KIRKLEES METROPOLITAN COUNCIL INVESTMENT & REGENERATION SERVICE

DELEGATED DECISION TO DETERMINE PLANNING APPLICATIONS

Reference No:	2024/62/90091/W
Site Address:	20, Upper Bank End Road, Holmfirth, HD9 1EW
Description:	Erection of single storey extension to side and rear with raised terrace and balustrade
Recommending Officer:	Joanna Rednall

HOUSEHOLDER DELEGATED REPORT

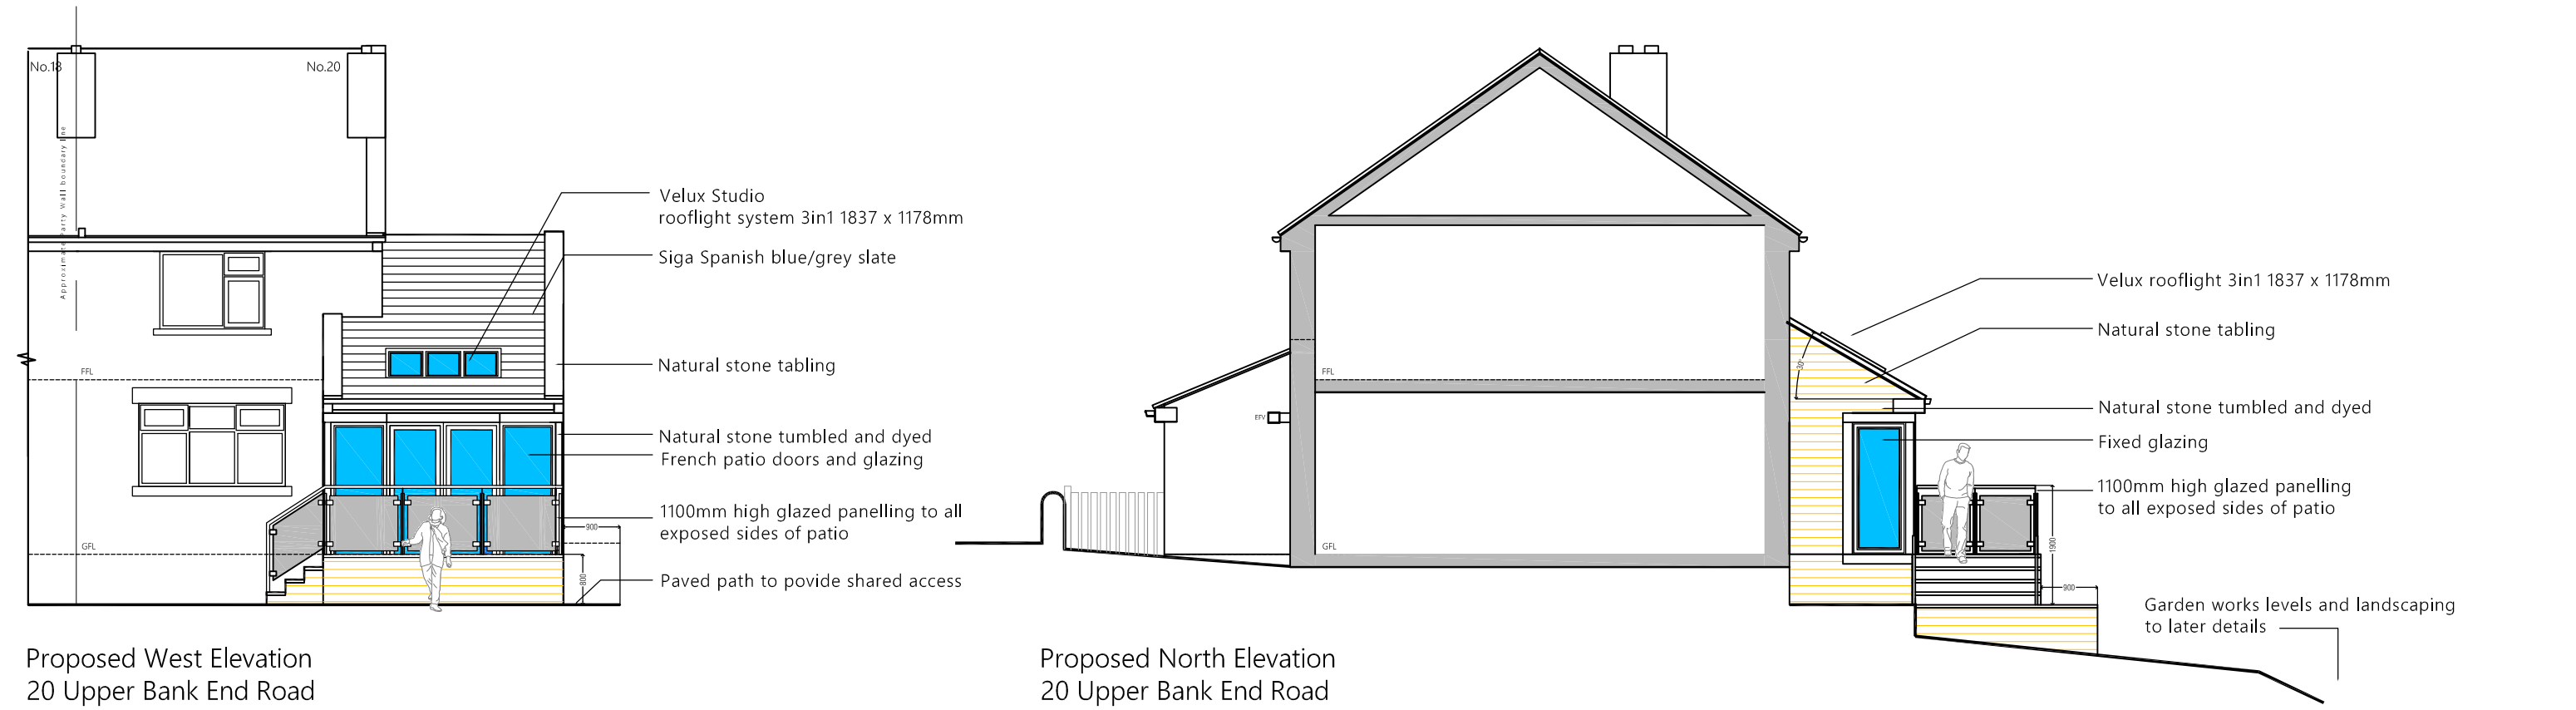
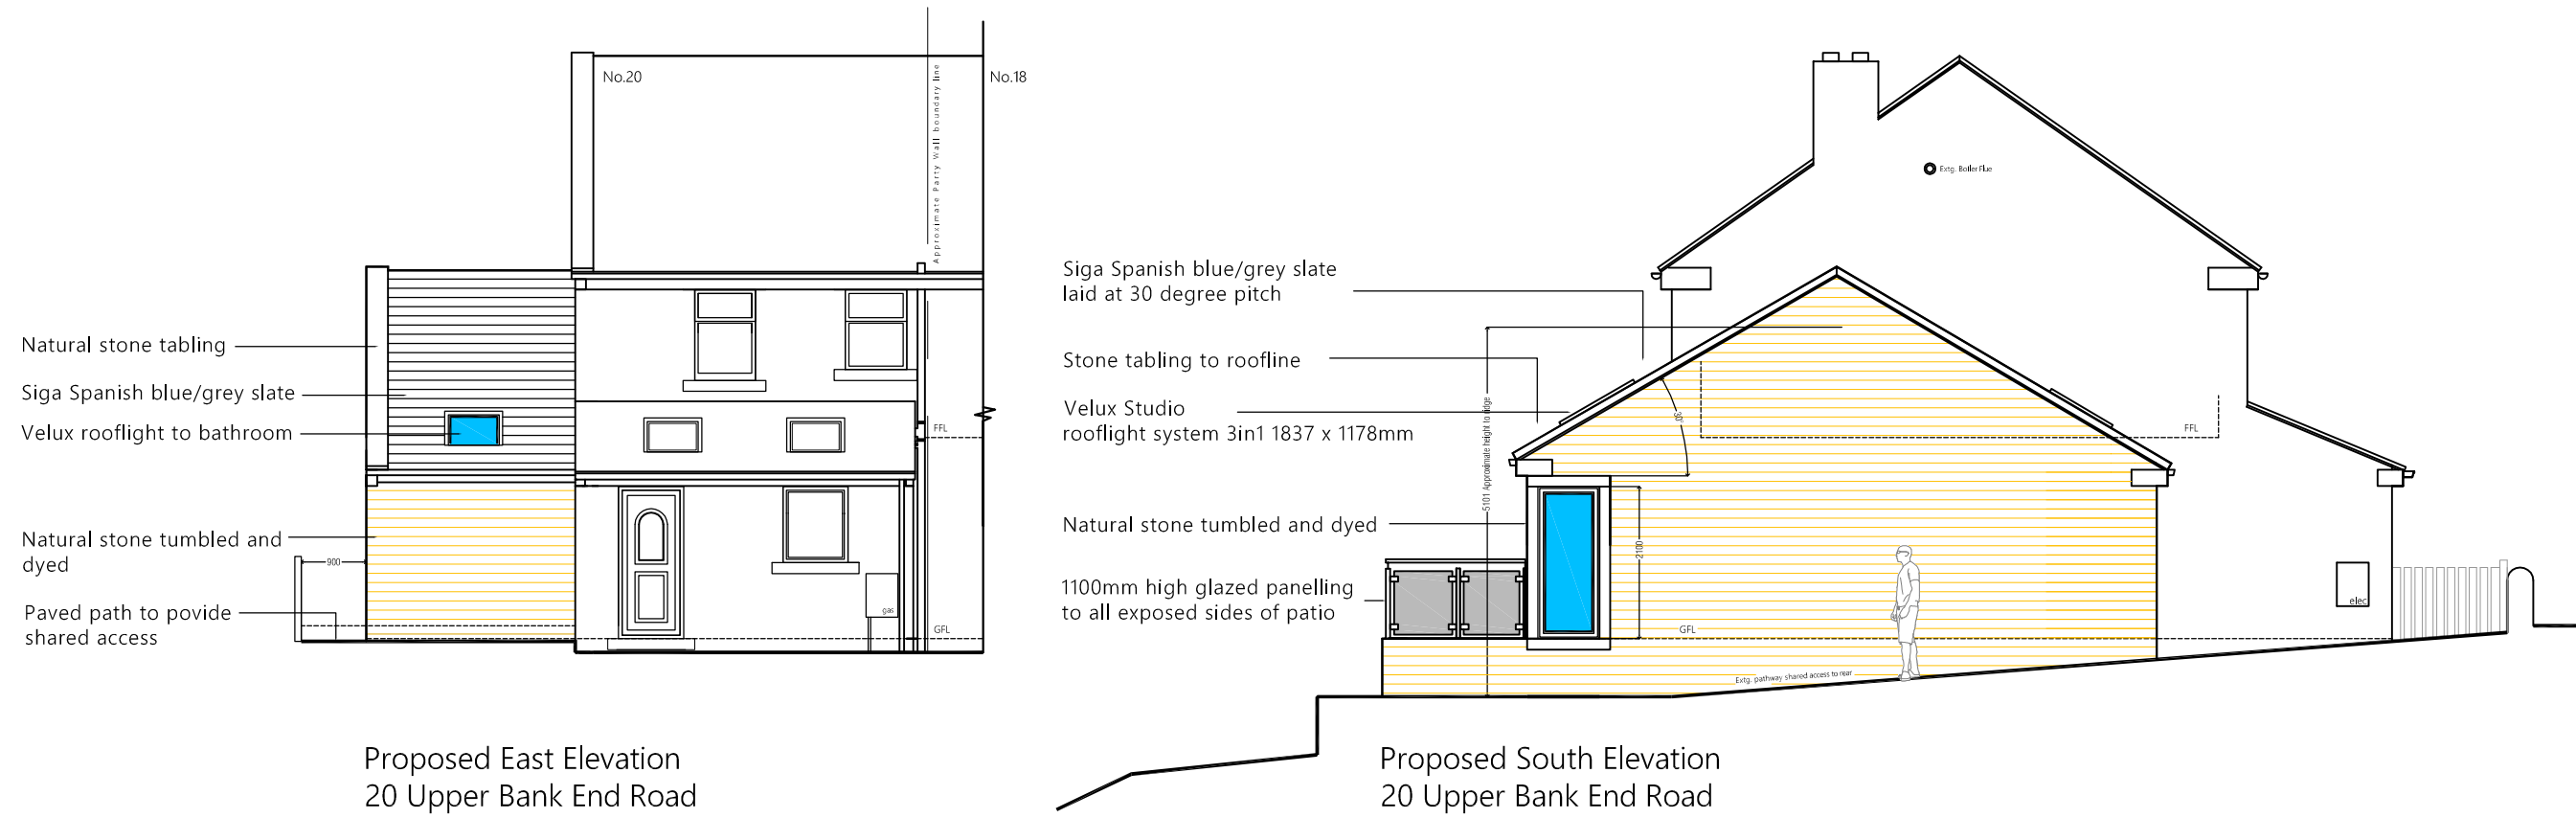
The single storey side extension would project ~2.8 metres from the south-facing elevation and extend ~6.7 metres along the side elevation of the application property. The eaves height would be ~2.6 metres with a total height of ~5.8 metres to the ridge of the gable roof. The side extension would be set back ~3.2 metres from the front elevation of 20 Upper Bank End Road and the front (east-facing elevation) roof slope of the extension would host one velux rooflight.

Within the rear (west facing) elevation of the extension would be French patio doors with one long glazed window either side of the patio doors, as well as an additional long window proposed within the side (south-facing) elevation of

The raised terrace would project ~2 metres from the rear elevation of the extension. It would have a width of ~3.8 metres and would be raised ~0.8 metres from external ground level with steps erected to allow access to and from the rear garden and rear extension. The proposed balustrade would be erected along the side and rear elevations of the terrace, and would have ~1.1 metre high glazed panelling to all exposed sides of the patio.

- *22, Upper Bank End Road – located to the south of the application site. The proposed extension would be set off the shared boundary by ~0.9 metres with a proposed full-length window on the corner of the side/rear extension which has some potential to overlook part of the rear amenity space at No.22, given that the extension would be elevated by ~0.8 metres. To prevent any detrimental impact on overlooking this window would be conditioned to be obscurely glazed, in addition a screen to this elevation of the raised terrace would be ensured by condition.*

Impact on privacy of neighbours (to sides, rear and front)	• KDP 3 & 4 of the SPD • Policy LP24 Design (d) (iv) • Policy 2 of the HVNDP • Chapter 12 of the NPPF	Window on side elevation to be conditioned as obscure glazed. Screening to be secured to the southern elevation of the terrace to prevent overlooking	✓
Impact on light and outlook of neighbours (to sides, rear and front)	• KDP 4, 5, 6 of the SPD • Policy LP24 Design (b) • Policy 2 of the HVNDP • Chapter 12 of the NPPF	Single storey in height with minimal rear projection would mitigate any detrimental impact on loss of light and outlook of neighbours.	✓
Remaining garden space of application property	• KDP 7 of the SPD • Policy LP24 Design (b) and (c) • Policy 2 of the HVNDP • Chapter 12 of the NPPF	Over half of rear garden space would be retained.	✓

4. The floor to ceiling height window serving the sitting room, in the southern side elevation of the extension hereby approved, shall be fitted with obscure glazing, minimum grade 4 before it is first occupied. Notwithstanding the provisions of section 55(2)(a)(ii) of the Town and Country Planning Act 1990 and the Town and Country Planning (General Permitted Development) Order 2015 (or any Order revoking or re-enacting that Order with or without modification) the said window shall thereafter be so retained obscure glazed.

5. Notwithstanding the plans submitted, the raised terrace shall not be brought into use until a 1.8 metre obscurely glazed screen (to a minimum privacy level of Grade 4 or equivalent) or timber fencing to a height of 1.8m high has been constructed to the southern elevation of the raised terrace. The obscure glazed screen or timber fencing shall thereafter be retained.
